**Our ref:** WA/2019/126833/01-L01  
**Your ref:** 19/01170/F  
**Date:** 30 July 2019

**Improvement of community facilities at Wendlebury Village Hall comprising construction of a disabled toilet, garage for community mini-bus, installation of bifold doors to rear of Hall (Re-submission of 18/01363/F)**

**Wendlebury Village Hall Main Street Wendlebury Bicester OX25 2PS**

Client	Village Hall	Title	
Project	Village Hall Wendelbury Oxfordshire	Proposed Plans & Elevations	
Scale	1:50	Drawing No	BW006 / 02

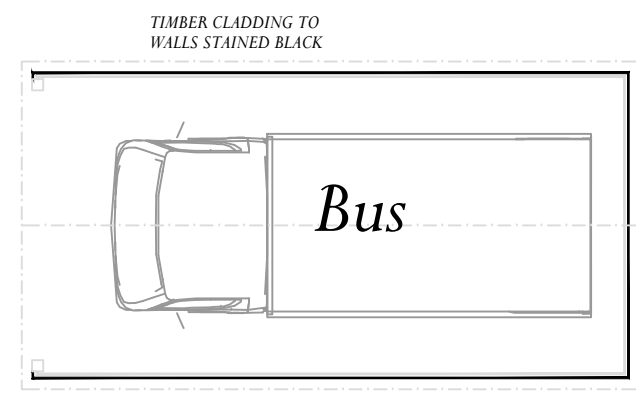
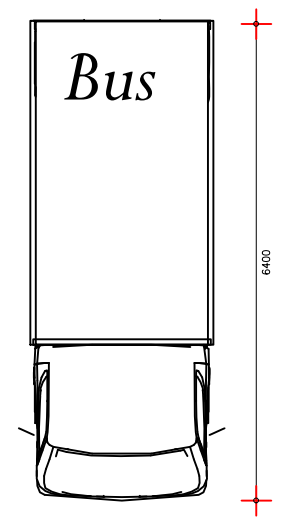
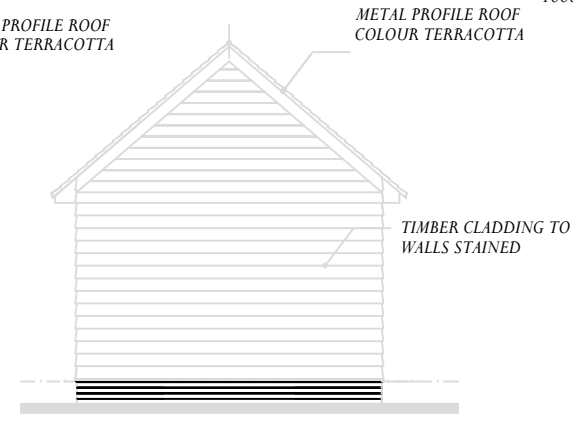
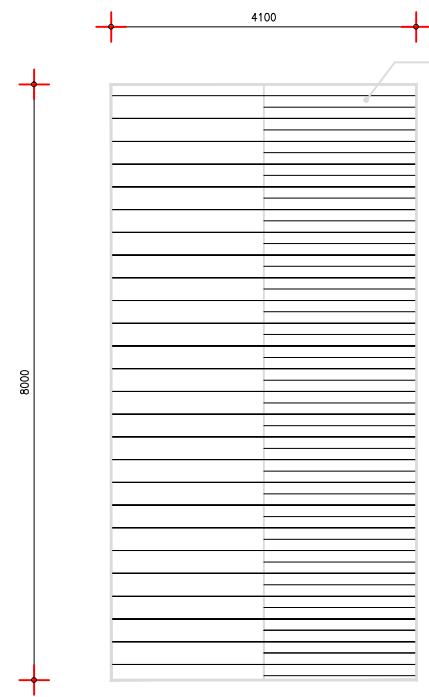
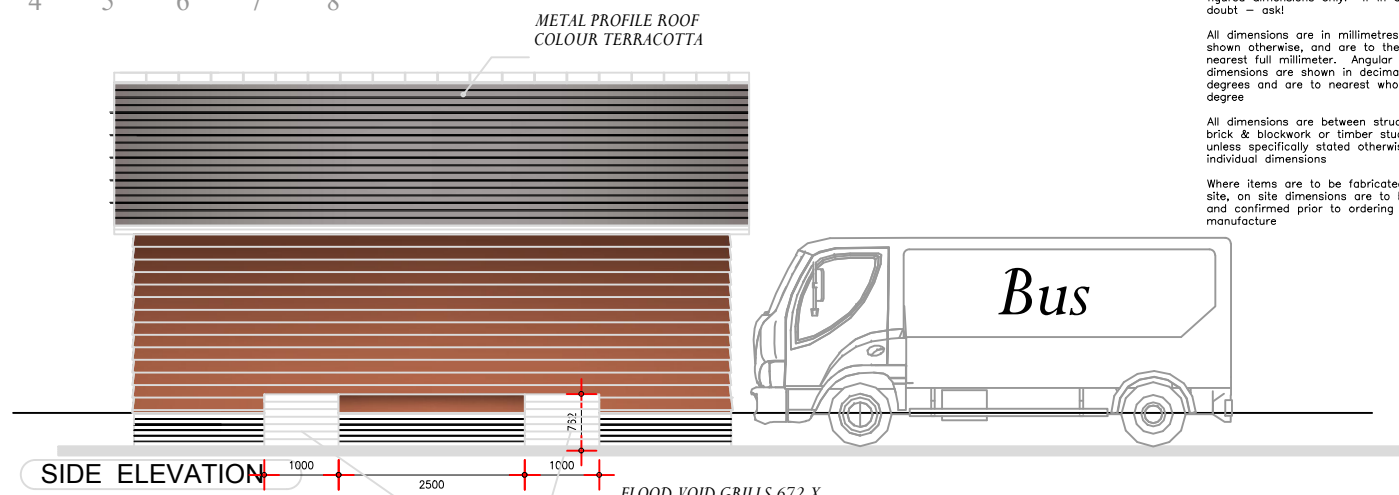
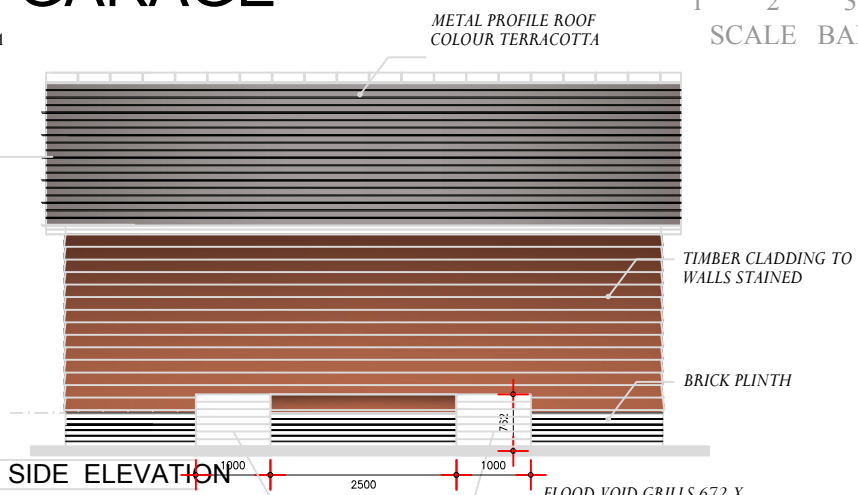
The development shall be carried out in accordance with the submitted Flood Risk Assessment, prepared by Flood Risk and Drainage Solutions, reference 2019-027, dated 2 April 2019 and the Proposed Plans and Elevations drawing, reference BW006/02, and the following mitigation measures it details:

- There shall be no raising of existing ground levels on the site.
- Void openings will be designed to be open all the way down to existing ground levels to allow for the free flow of water during a flood event.
- The soffit level of the proposed voids will be set no lower than 63.000m AOD (0.762m high) and be a minimum width of 1m.
- The applicant will sign up to Environment Agency flood alerts and flood warnings for the site.
